Application No: EP/142/21/HH
Site Address: 38 Vermont Drive East Preston BN16 1LG
Description of works: Conversion of roofspace to habitable use to include 2 x side dormers, Juliet balcony and conversion of roof from hip to gable end and single storey ground infill extension.

Thank you for your internet representation made on 2nd December 2021 which has been recorded as an objection with the comments as follows:

The Planning & Licensing Committee of this council considered this Application at its meeting on Monday, 29th November.

ARW Design	DRAWING TITLE: PROPOSED ELEVATIONS PROJECT: PROPOSED LOFT CONVERSION WITH HIP TO GABLE END & DORMERS TO SIDE ELEVATIONS		LOCATION: 38, VERMONT DRIVE, EAST PRESTON CLIENT: C. NORTH		SCALE: AS NOTED @ paper size A3 DATE: OCT 2021		DRAWING NO: 6037/2
					DRAWN: ARW		
					REVISION:

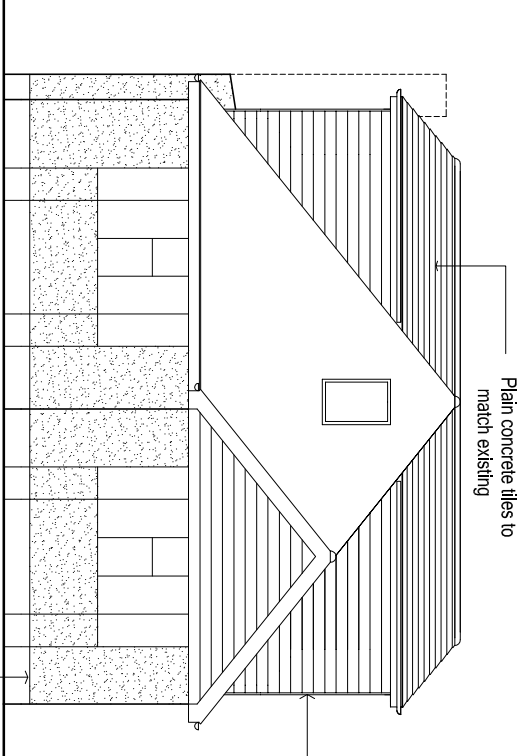
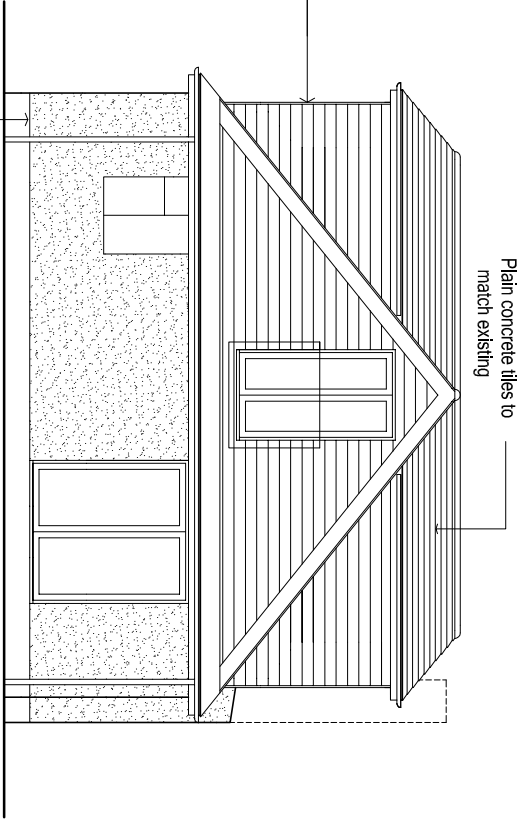
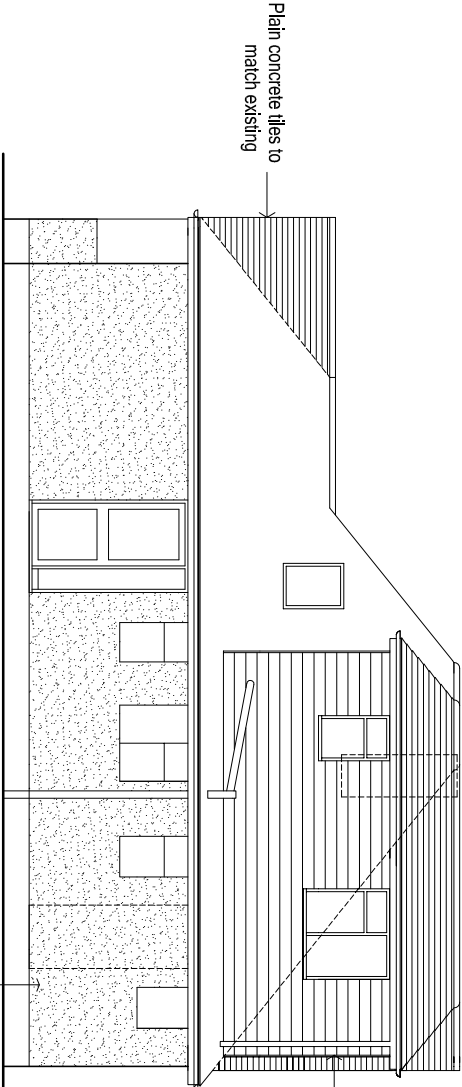
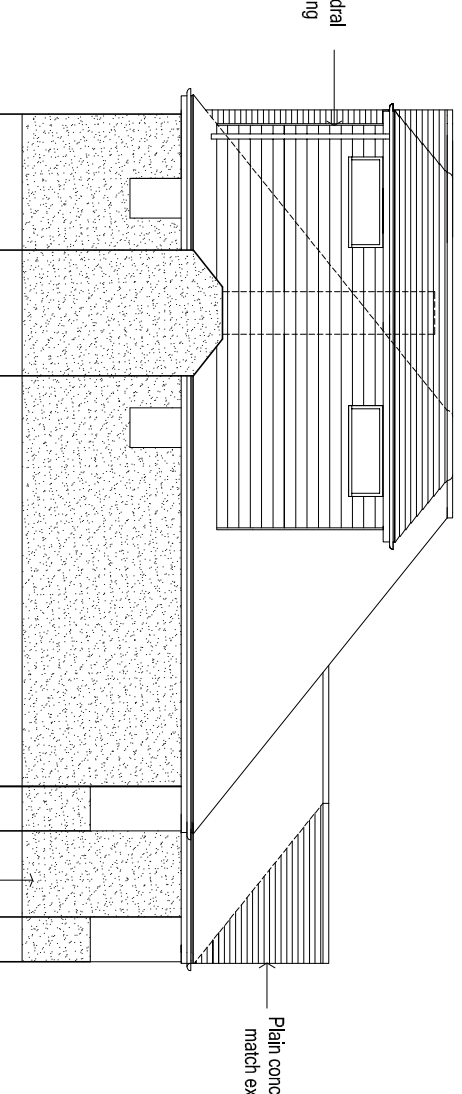
The committee agreed to object to this Application as the proposal will result in an unbalanced and possibly unattractive building. The developments proposed will have a negative impact upon the streetscene - most properties in this part of Vermont Drive are still bungalows. The proposed dormers are certainly not subservient to the main roof and are therefore contrary to the East Preston Neighbourhood Plan. The committee felt the proposal was also contrary to Arun's Local Plan and the National Planning Policy Framework.
